SSD 9227: RESPONSE TO SUBMISSIONS, PROPOSED AMITY COLLEGE SCHOOL CAMPUS AT No.85 BYRON ROAD AND No.63 INGLEBURN ROAD, LOTS 1 & 2 DP 525996, LEPPINGTON, NSW

Proposed Amity College school campus, Leppington NSW: SSD 9227
Outline Planning Consultants Pty Ltd
Town Planners & Project Managers

DRAWING TITLE			
DRAINAGE LONGITUDINAL SECTIONS (SHEET 1)			
PROJECT NO.	PLANSET NO.	RELEASE NO.	DRAWING NO.
P18064.93	PS01	R11	PS01-E300
REVISION			
F

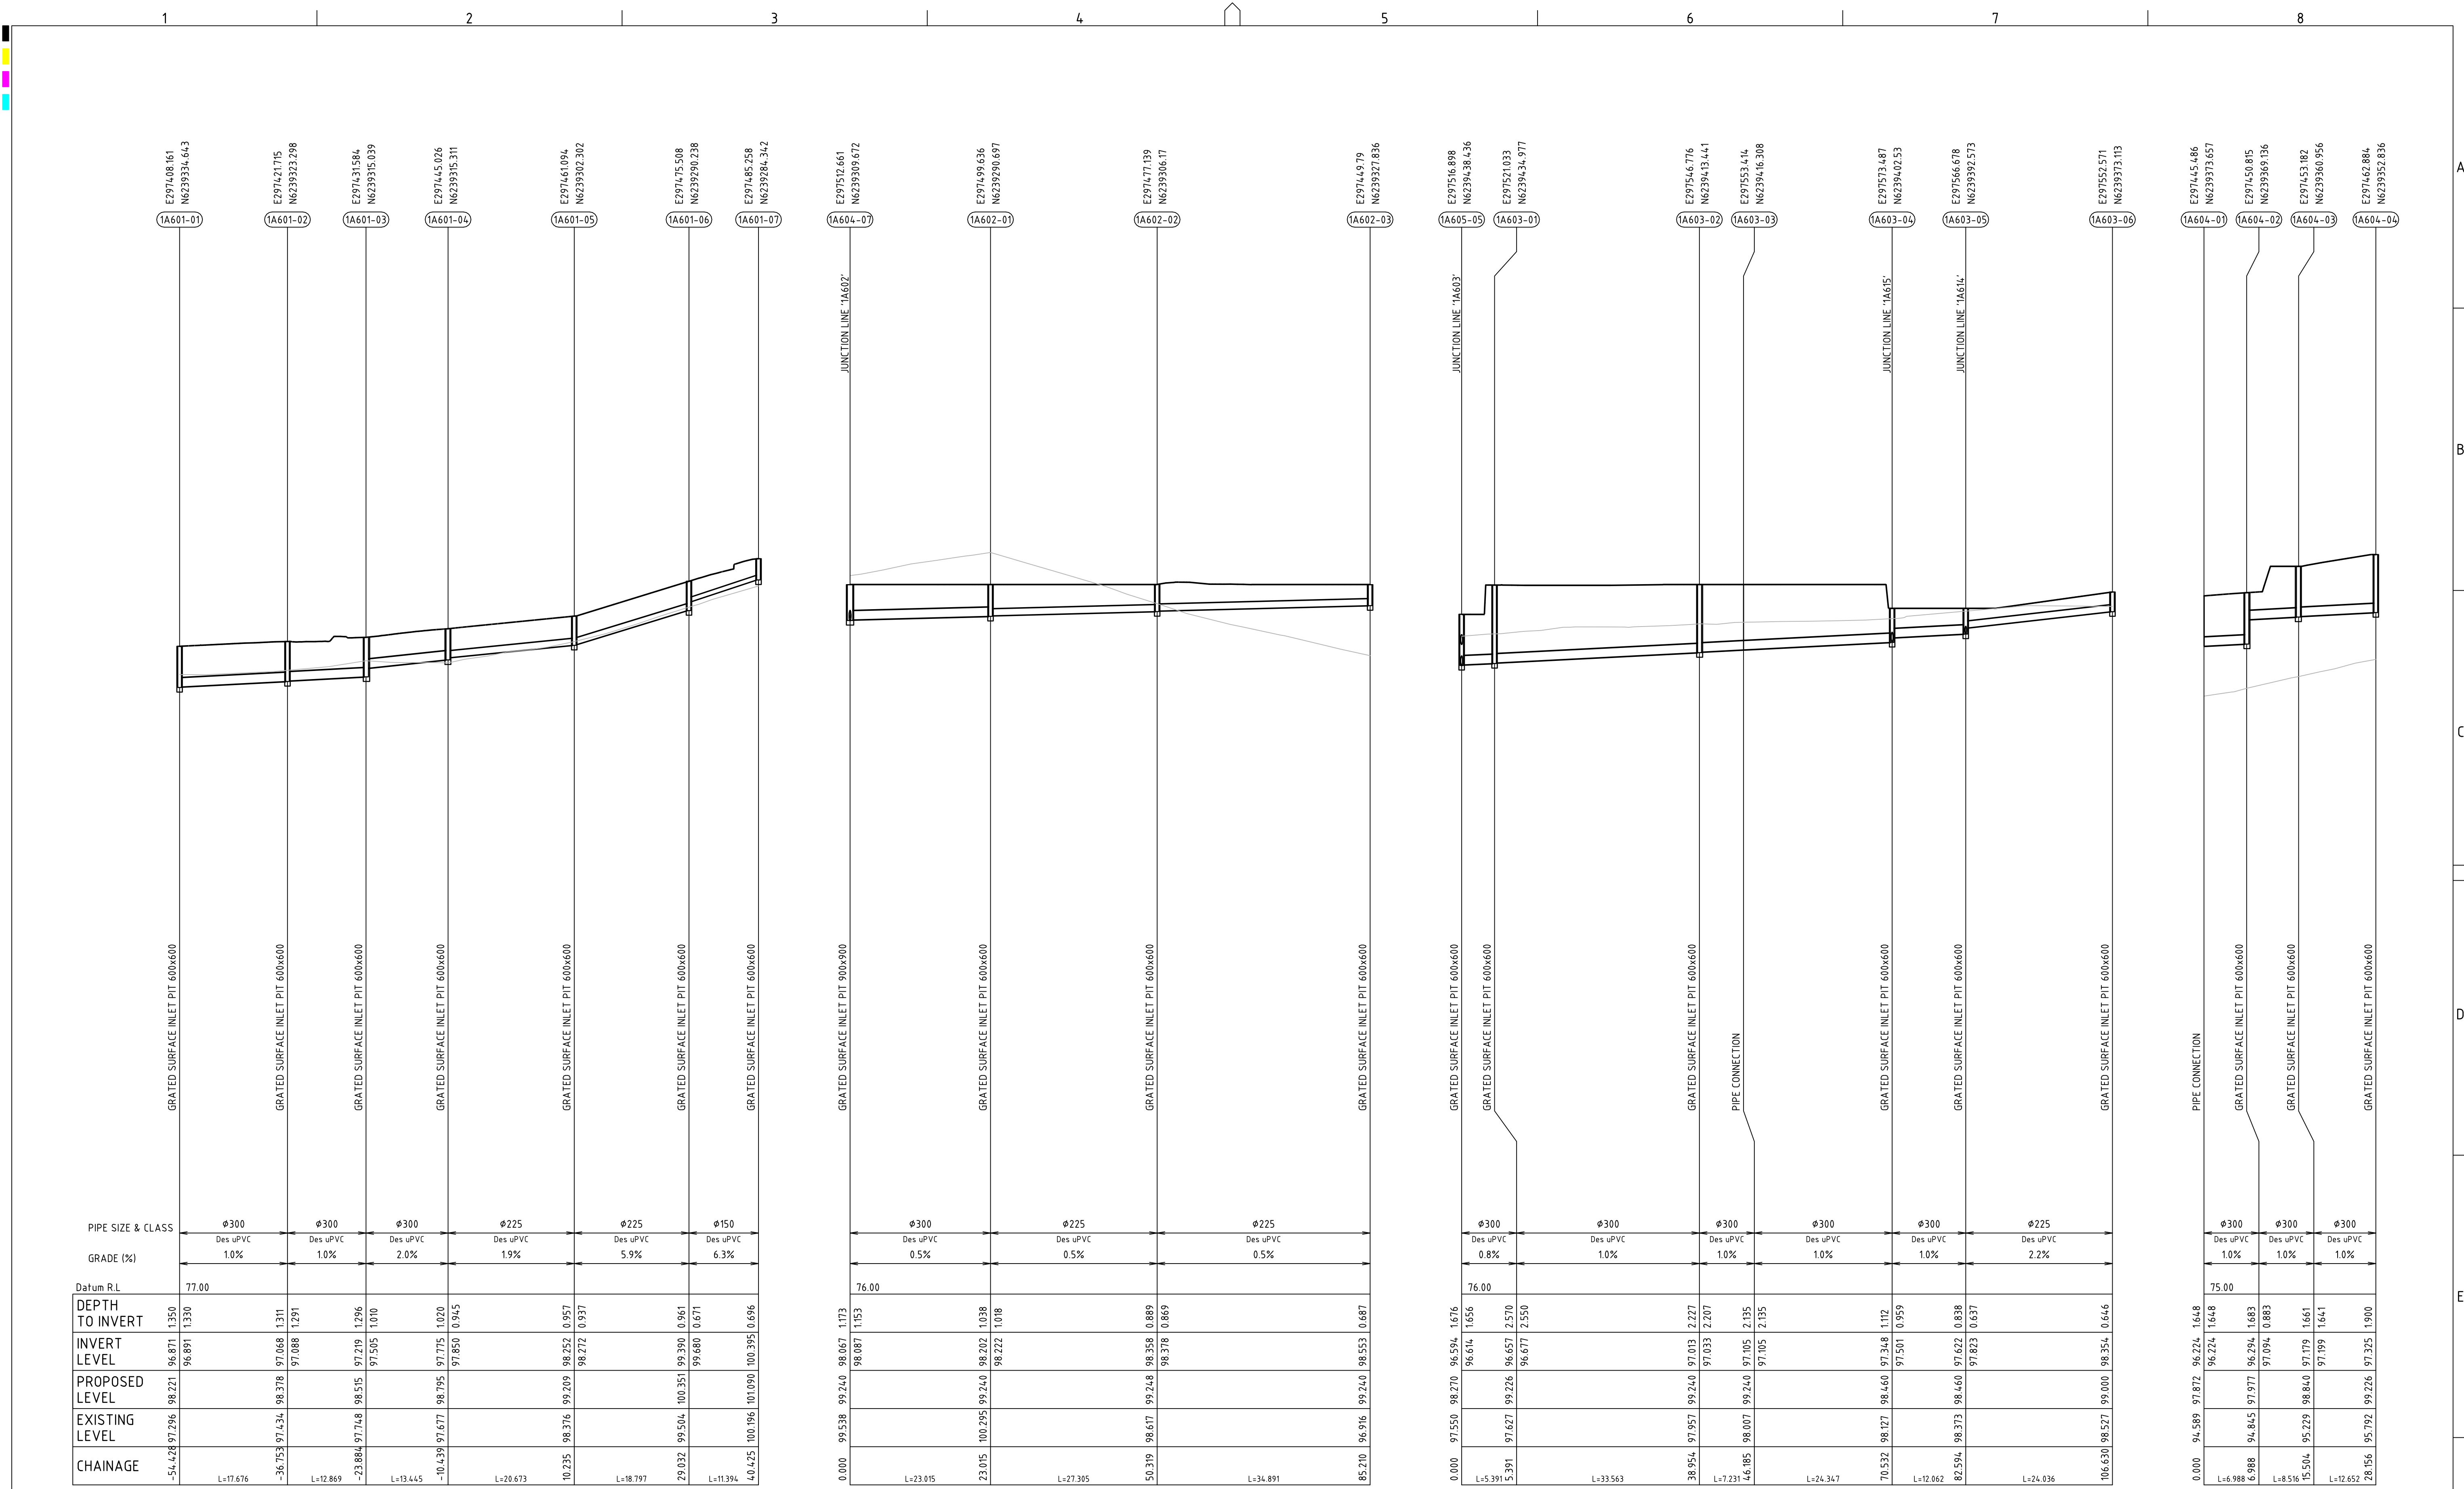
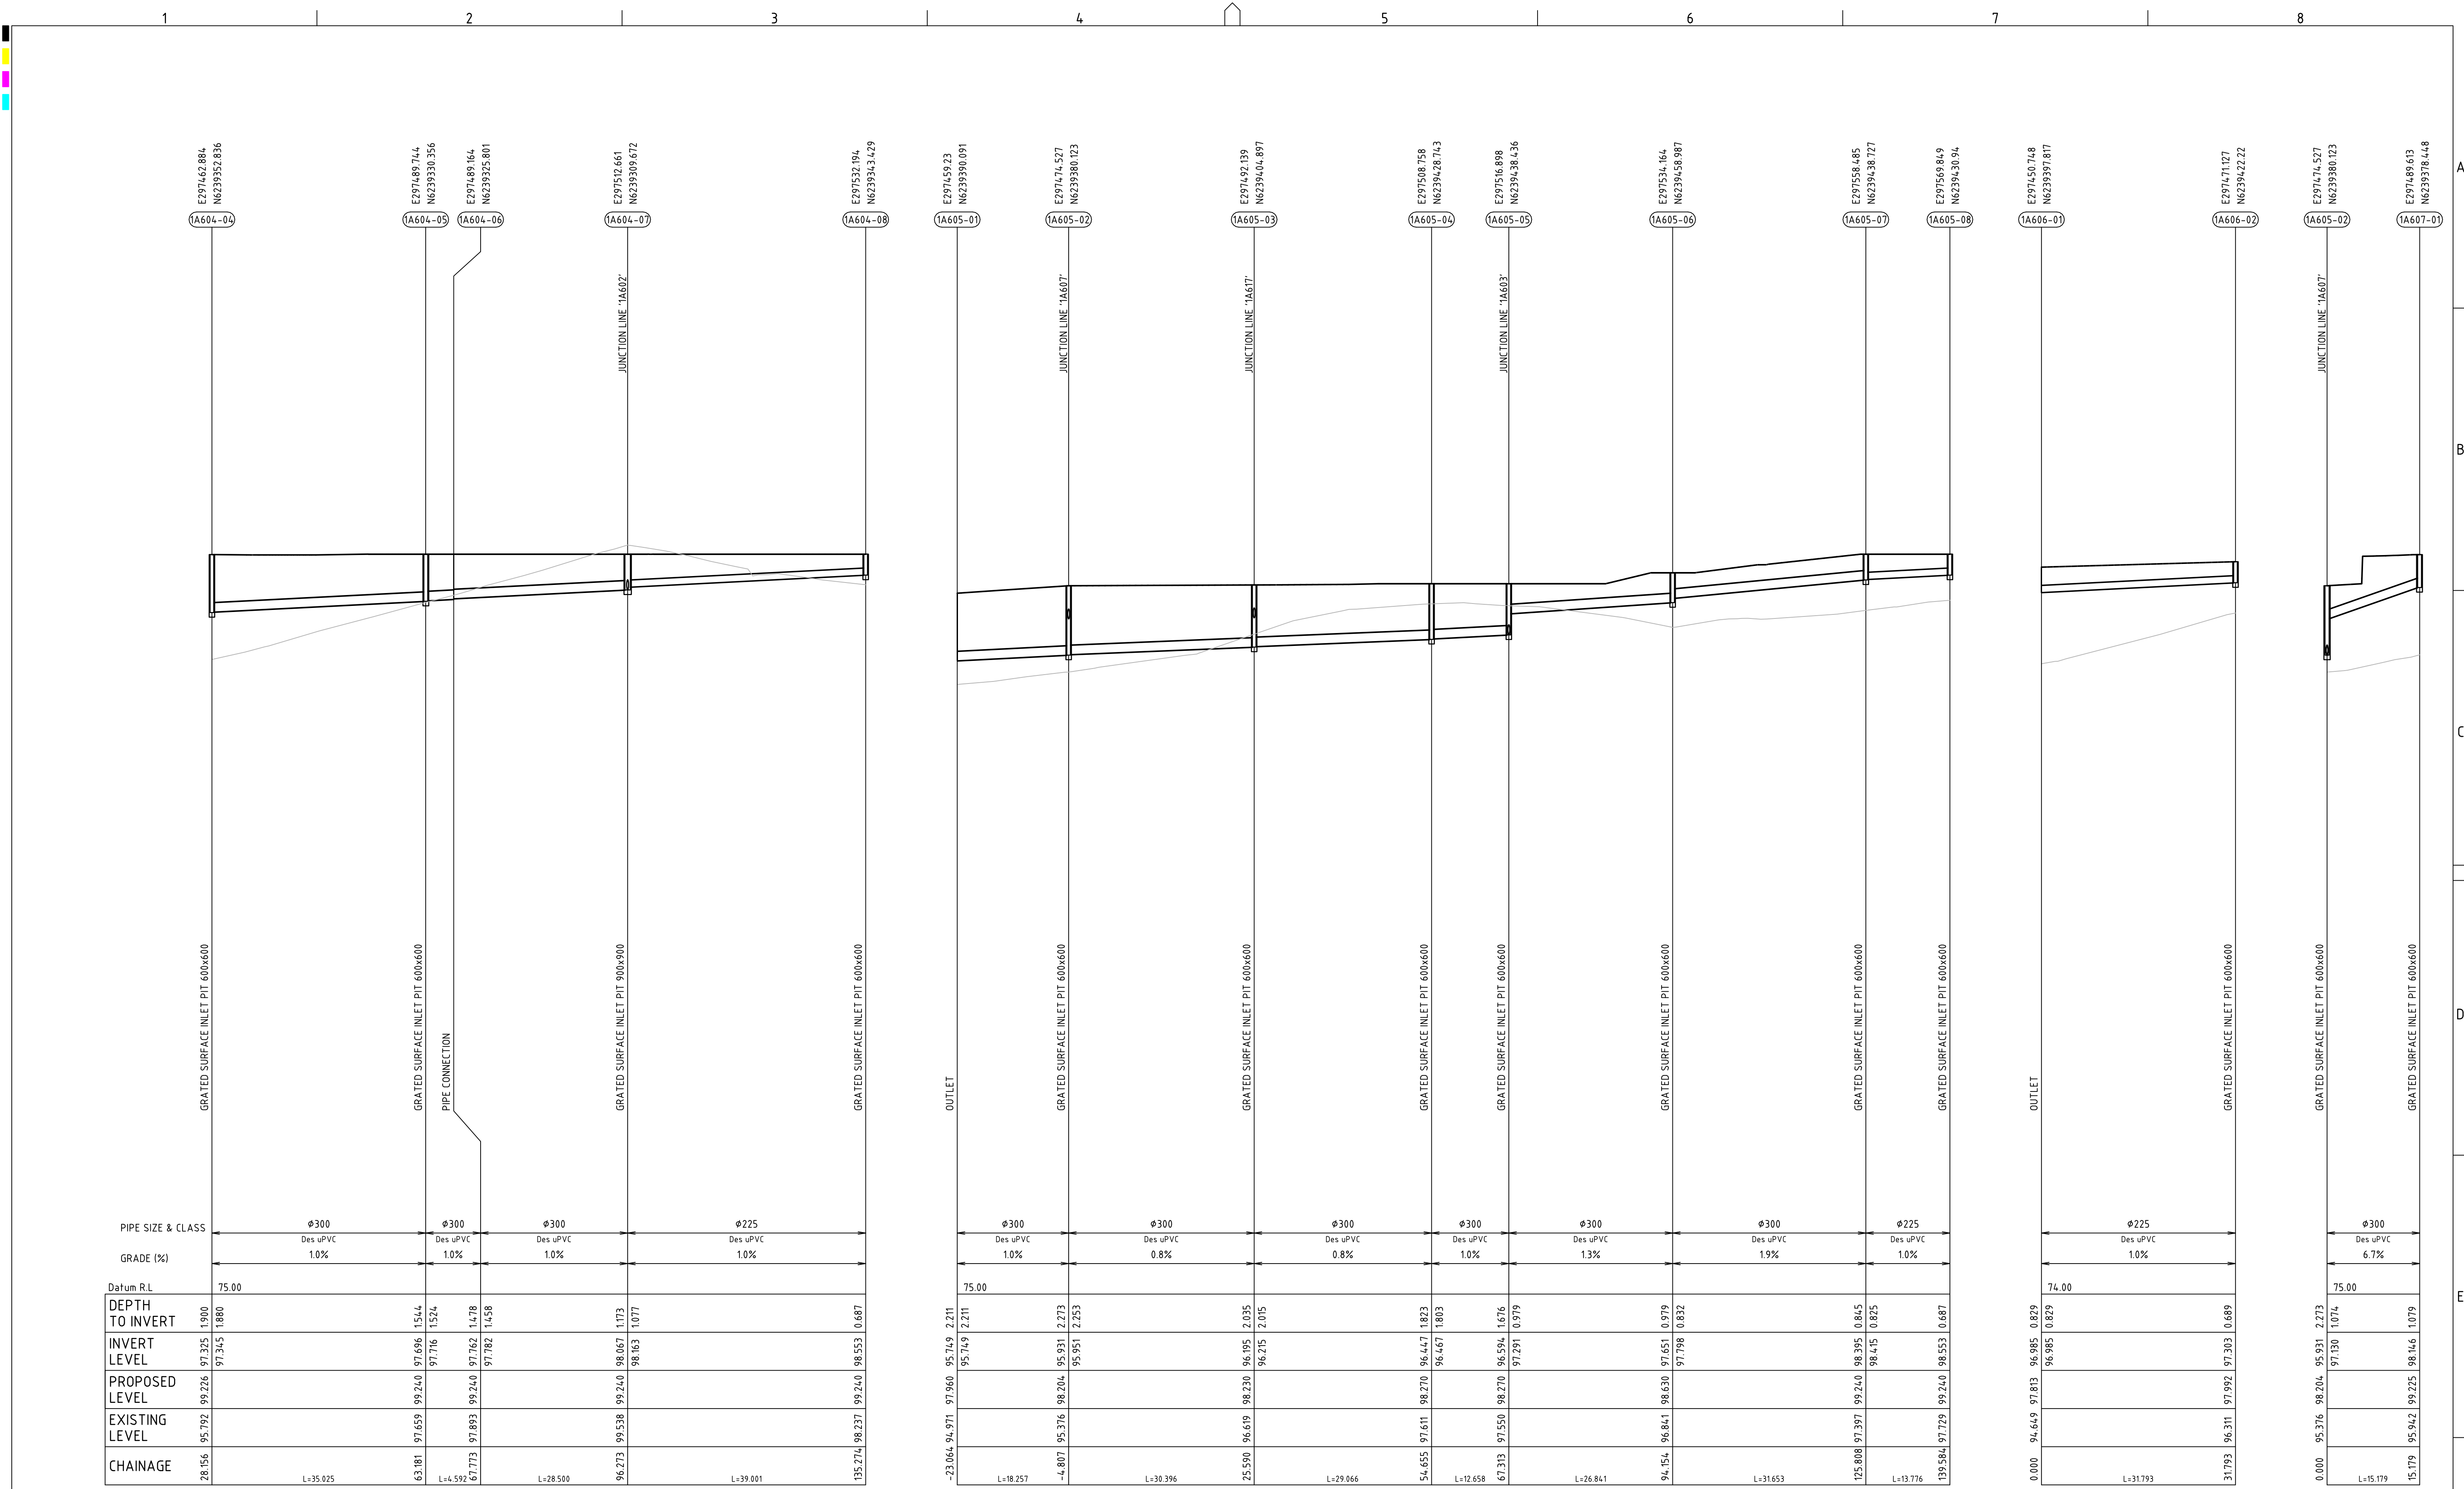
“11. In accordance with the Leppington precinct’s indicative layout plan and water cycle management strategy, the stormwater flows from 63 Ingleburn are to drain to the zoned drainage reserve near 75 Ingleburn Road. Due to these requirements, the following needs to be considered, modelled and incorporated into the drainage design:

- overland flows should not be conveyed through 69 Ingleburn Road as this site is zoned for public open space. A drainage swale is not appropriate through this space,
- the 1% annual exceedance probability (AEP) level flows, from the post development external (in accordance with the indicative layout plan and water cycle management strategy) and internal catchment, are to discharge into the drainage reserve and eventually online regional drainage basin B9, and
- the development and internal roads need to be at or above the post development flood planning level (not the existing flood planning level).”

Not agreed, however, the design of the stormwater drainage system has been modified in order that some of the stormwater flows are directed back into the adjoining Pluto Avenue (road 1) stormwater drainage system, details of which are provided below. In providing the above, the proponent is achieving, in part, Council’s wishes.

- ▶ As requested by Camden Council, and based on the stormwater drainage model and stormwater engineering design used by Crownland’s consulting engineers Mott MacDonald, Martens & Associates have devised a stormwater system that **diverts stormwater from more than 3,000 square metres of the flows from the Amity College school site into the Crownland Pluto Avenue road drainage system**. Additional flows cannot be diverted to this system based on the carrying capacity of the existing stormwater system in the road. Refer **Appendix C** for details.

- ▶ All other stormwater flows within this catchment will be diverted back to the natural low-point on the school site, and thence to the natural drain line that runs to the west of the school (ie. Over the land zoned open space). Stated another way, the residue of stormwater flows will continue to naturally drain into the land below at No. 69 Ingleburn Road.
